Sent: 21 April 2015 12:19
To: Juan Baeza; Planning.Responses
Subject: Network Rail consultation - LU/385/14/PL

Network Rail have a number of concerns relating to the proposed development of a solar energy park at Brook Barn Farm, Courtwick Lane, Littlehampton, BN17 7PX and are outlined below.

APPLICATION SITE ACCESS AND ON-SITE VEHICLE ARRANGEMENTS

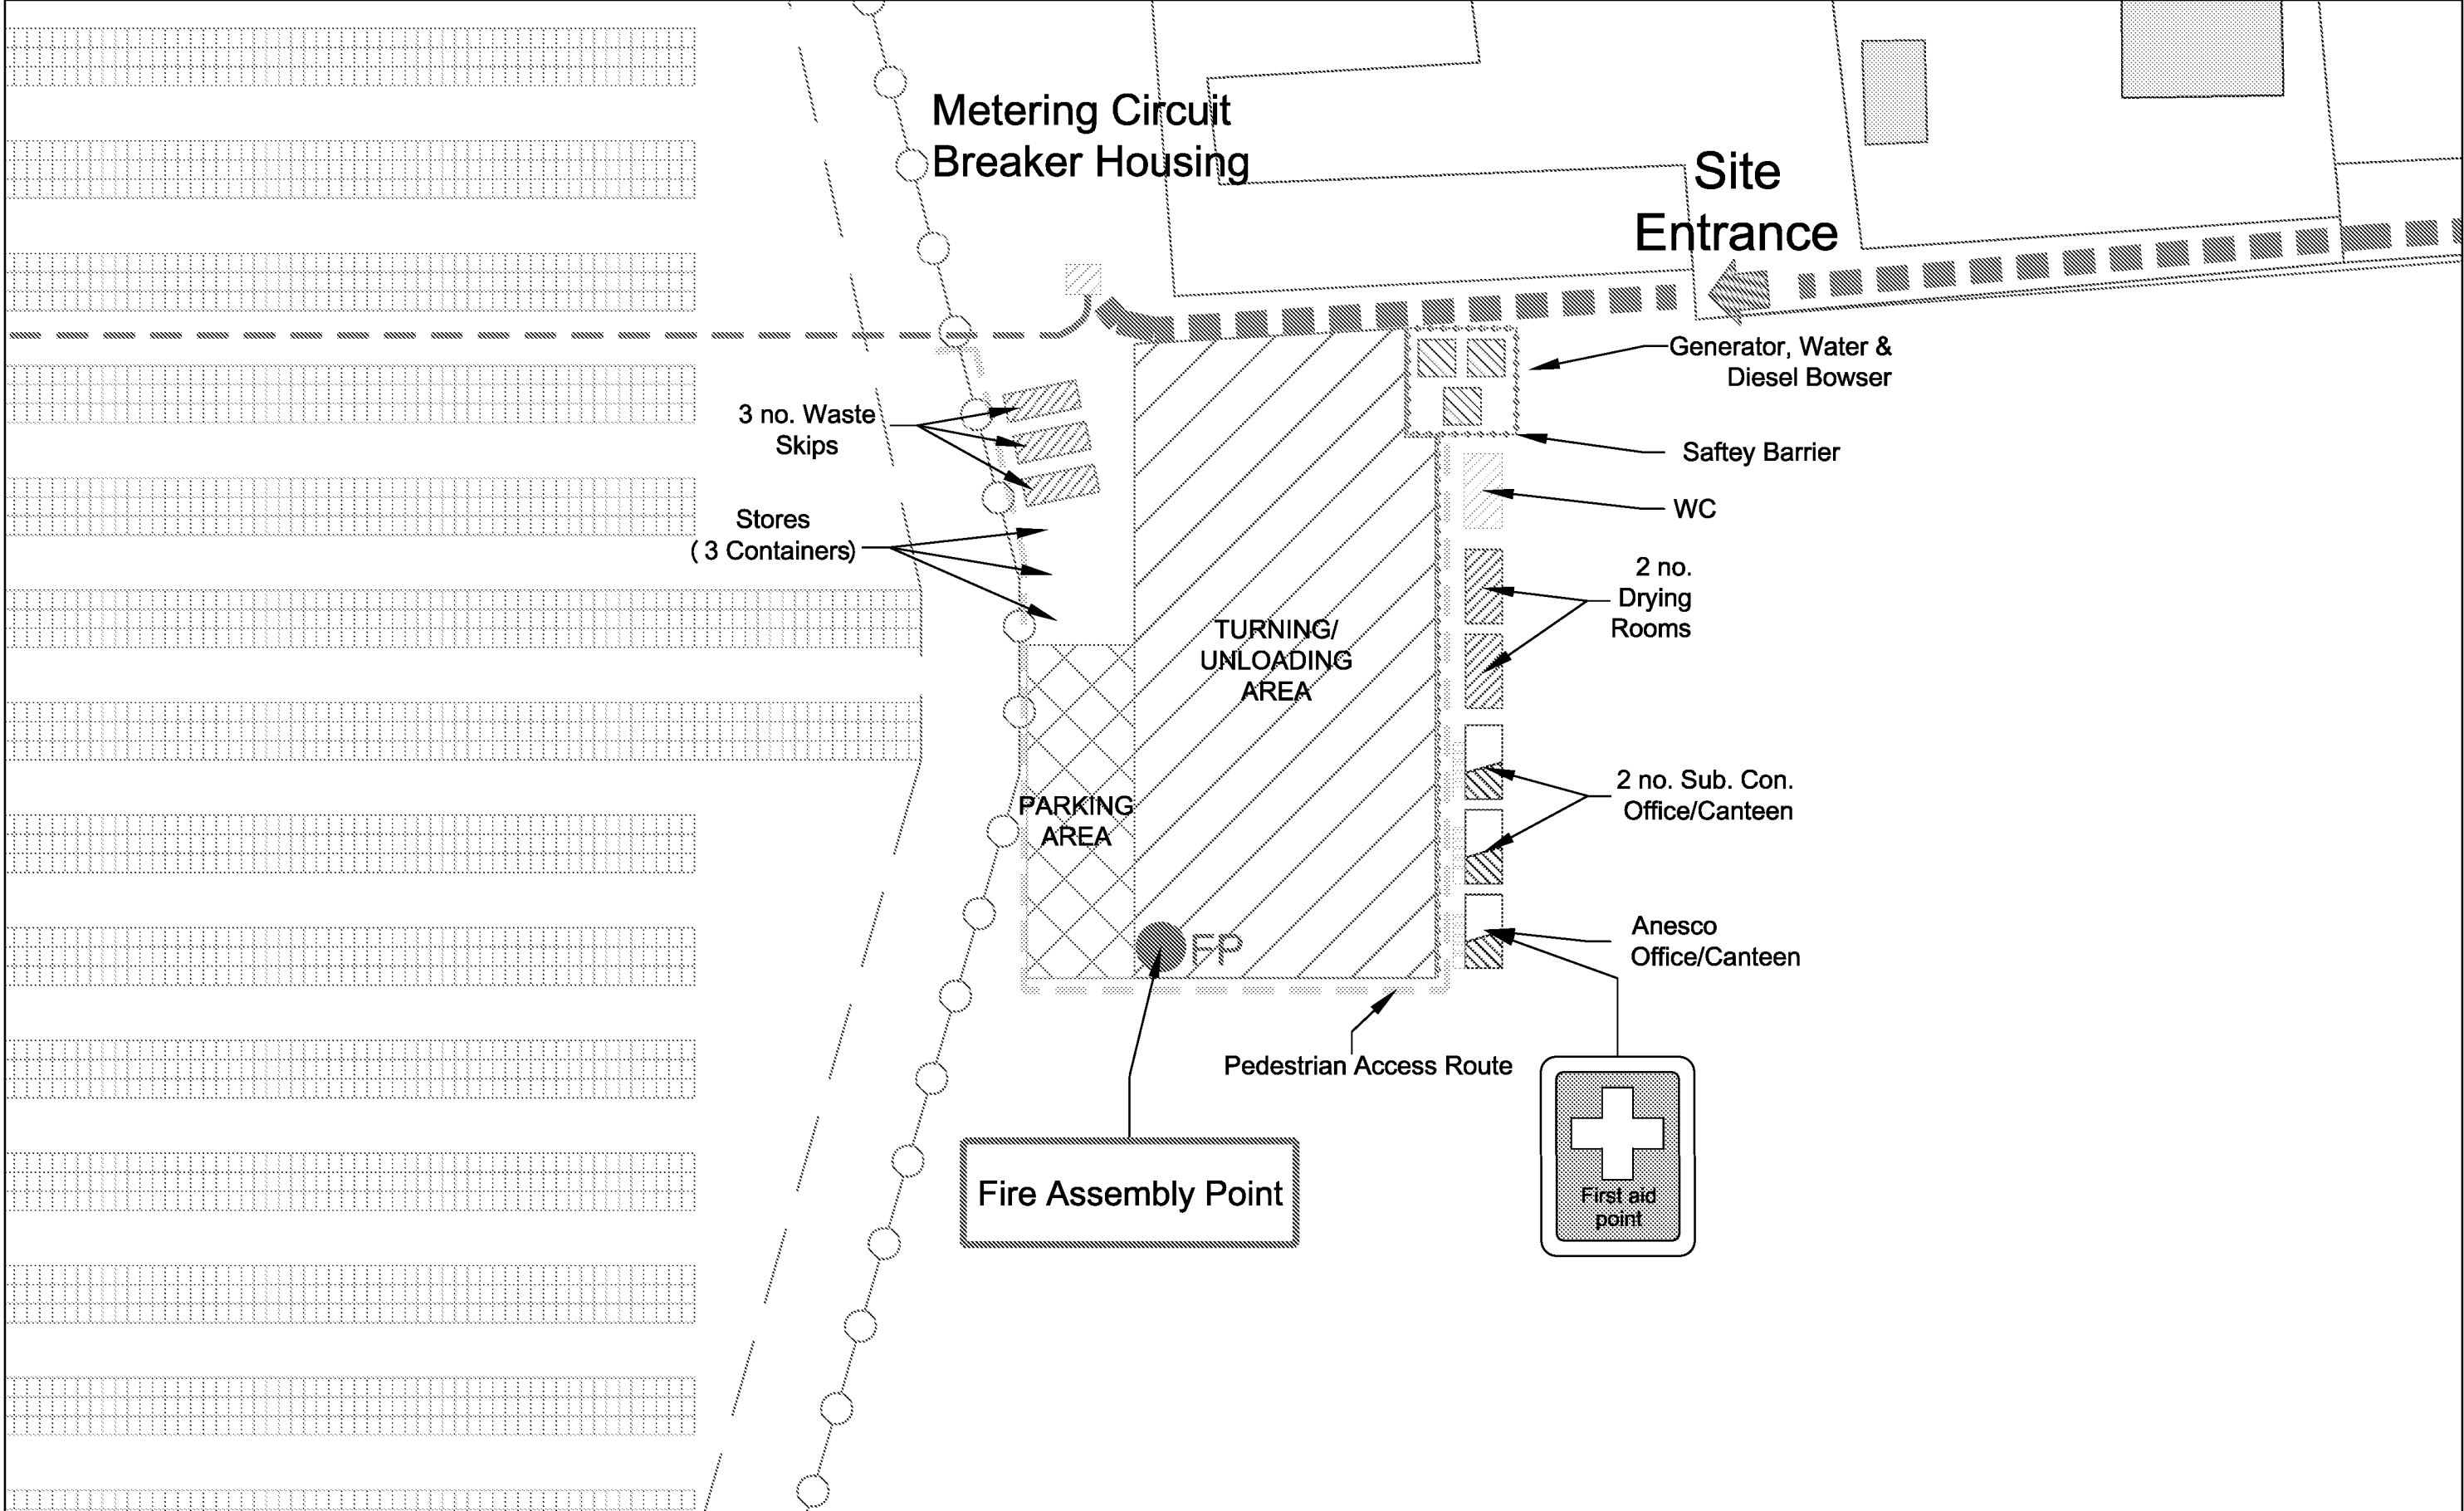
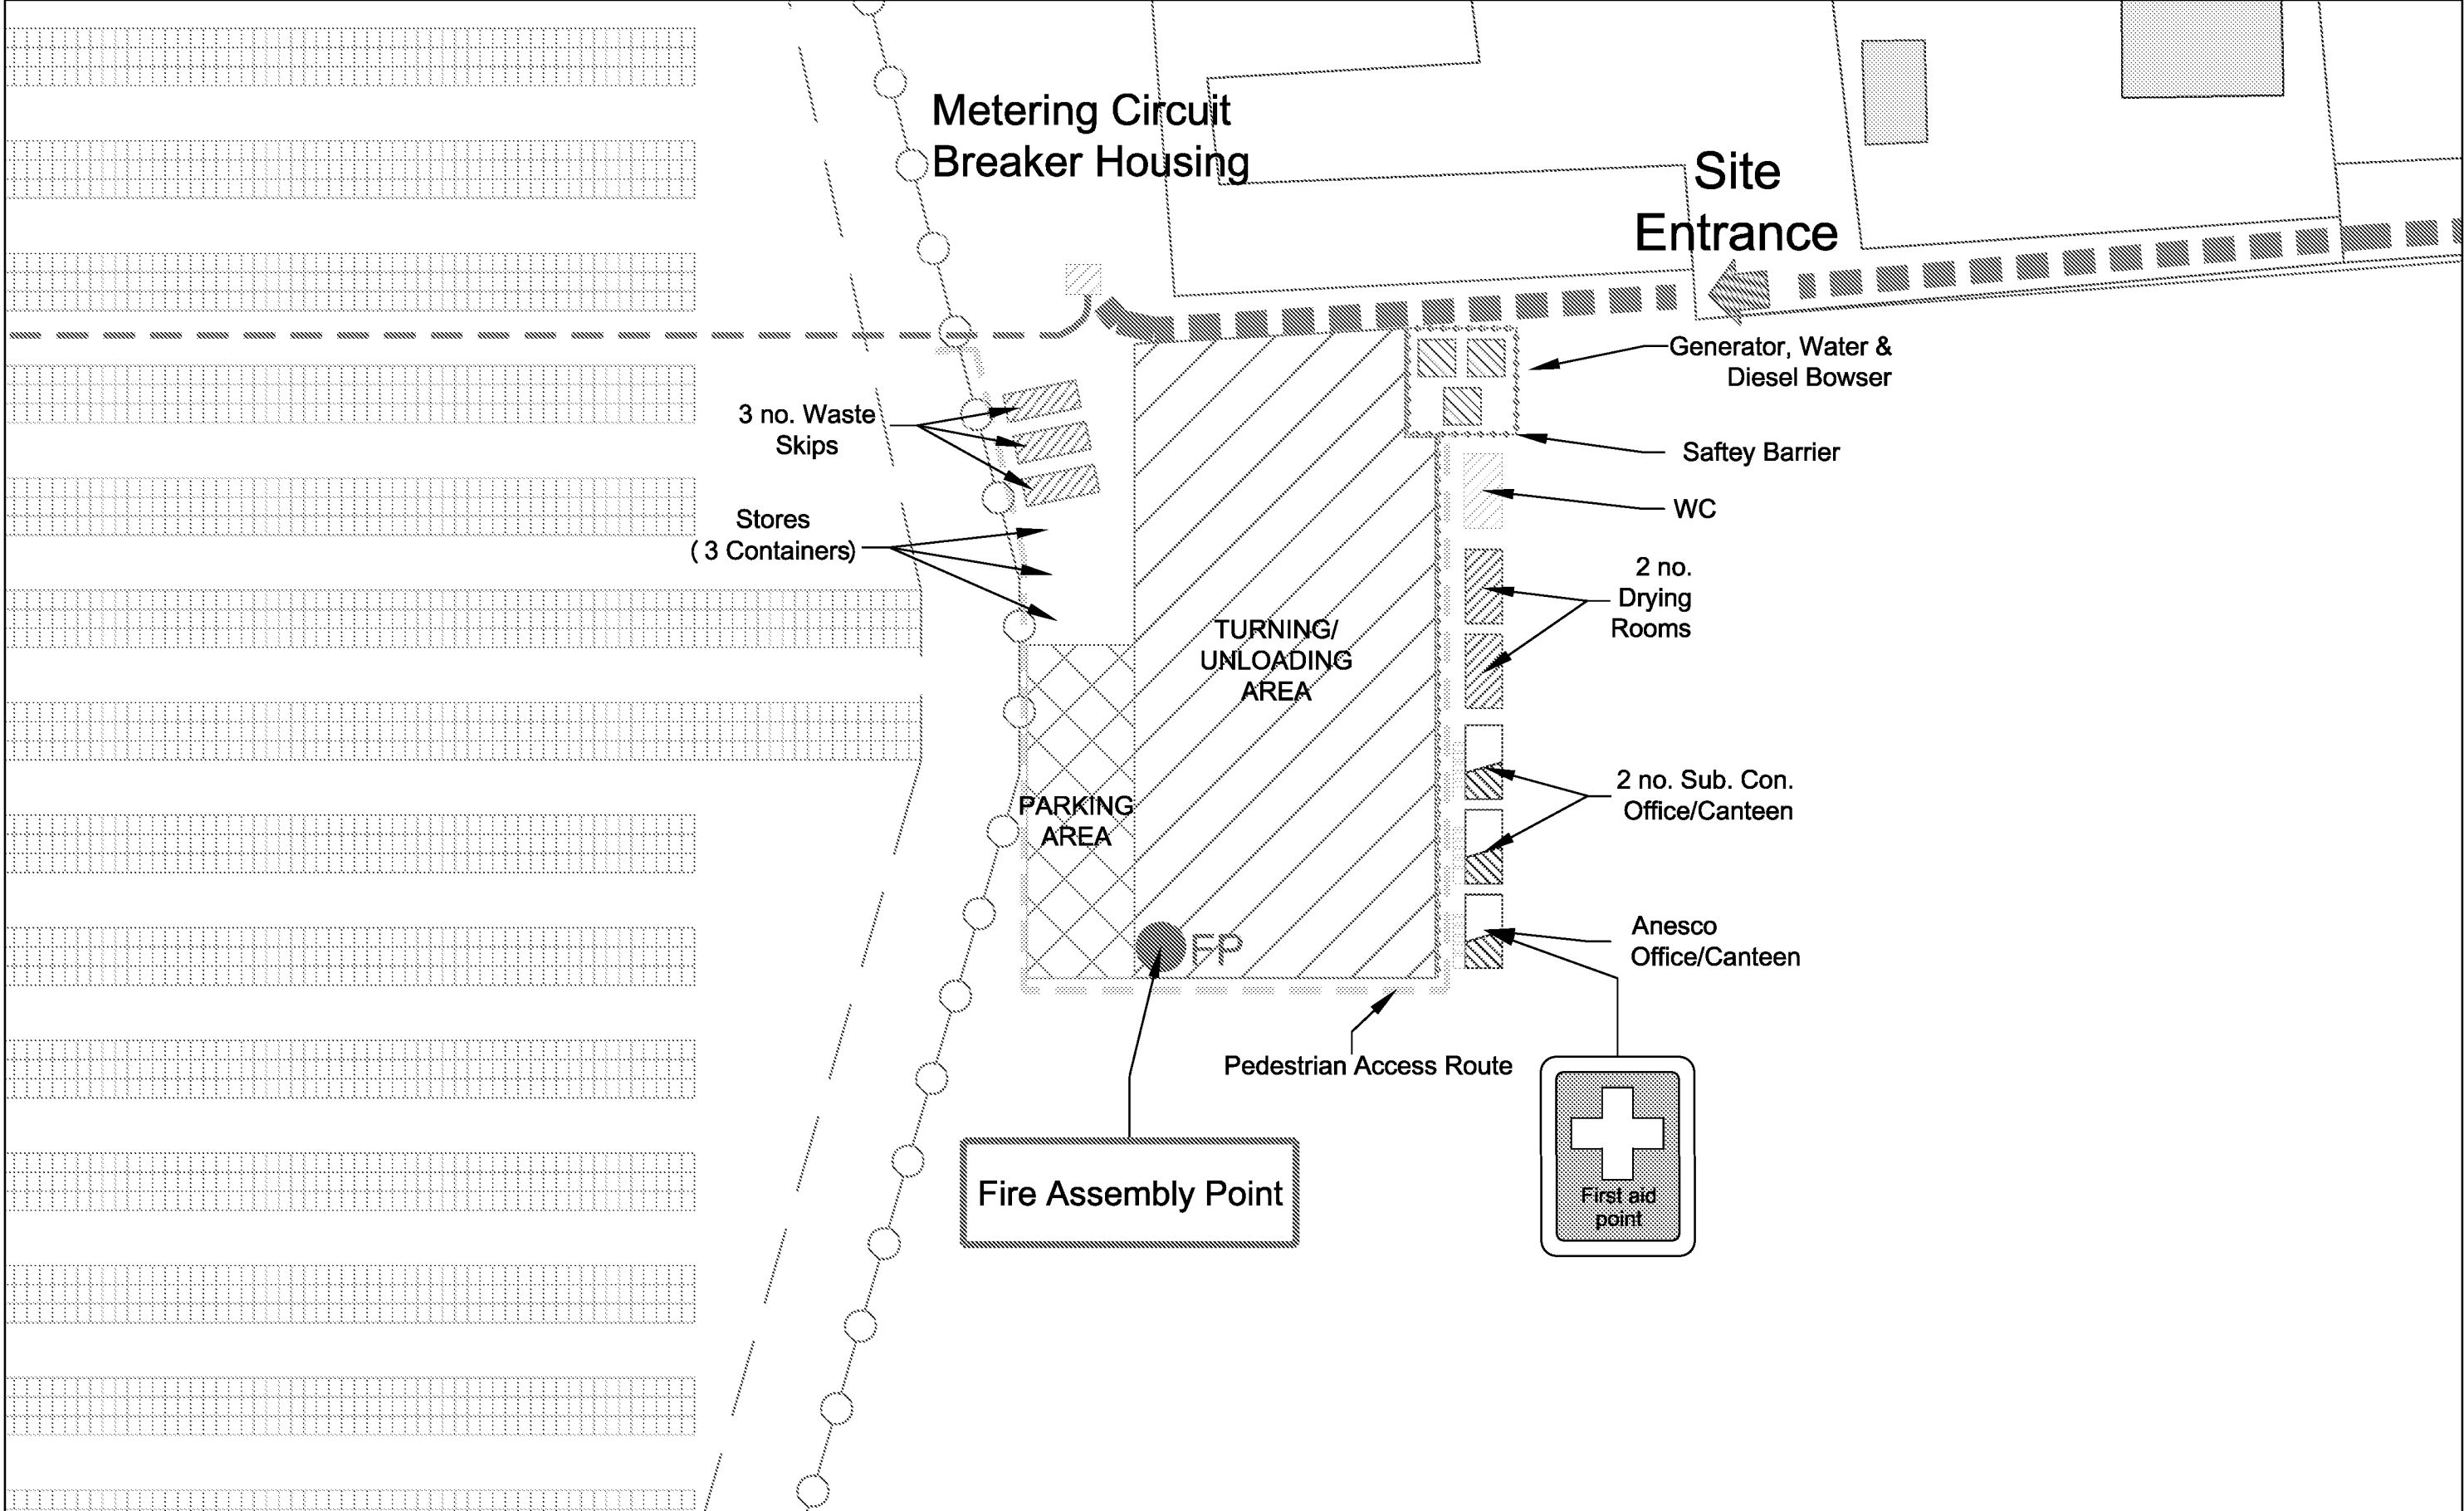
Should the tunnel /underpass be used for construction traffic it must be assessed to ensure that it is of sufficient size to allow such traffic through without causing any damage. Network Rail would be required to review the construction access plan to review what precautions are proposed to ensure the safety of such structures.
